Re: **Porch Beam Issue**
Location: Lot 159 The Farm (104 Barn Door Dr. (Lillington, NC))
JDS Project No.: RDU2403386
Date of Inspection: 4/2/2024

The client requested an evaluation of the (2) 2x12 dropped beam spanning left to right approximately 14'3" installed at the rear porch instead of installing (2) ply 1-3/4"x9-1/4" LVL beam per sheet S-2 of the building plans. additionally installed (1) 4x4 post instead of installing 6x6 post.

2A FOUND. DETAIL AT PATIO OR COVERED PORCH
 SCALE: 1" = 1'-0"

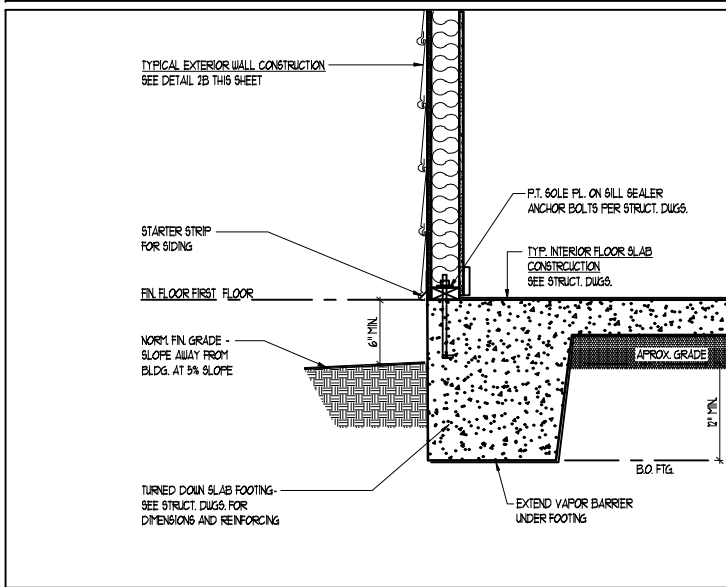
Based on our on-site observation and review, the (2) 2x12 beams are not sufficient for the structural loading conditions. Support all relevant framing and replace the 4x4 post with a new 6x6 pressure-treated post then, add (1) 2x12 beam spanning left to right scab at the front of the existing (2) 2x12 beam and attach it with (4) rows of 10d nails spaced 12" on center. The right end should be bearing on (3) 2x4 stud column and the left end bearing on the new 6x6 post providing a minimum 2" of bearing.
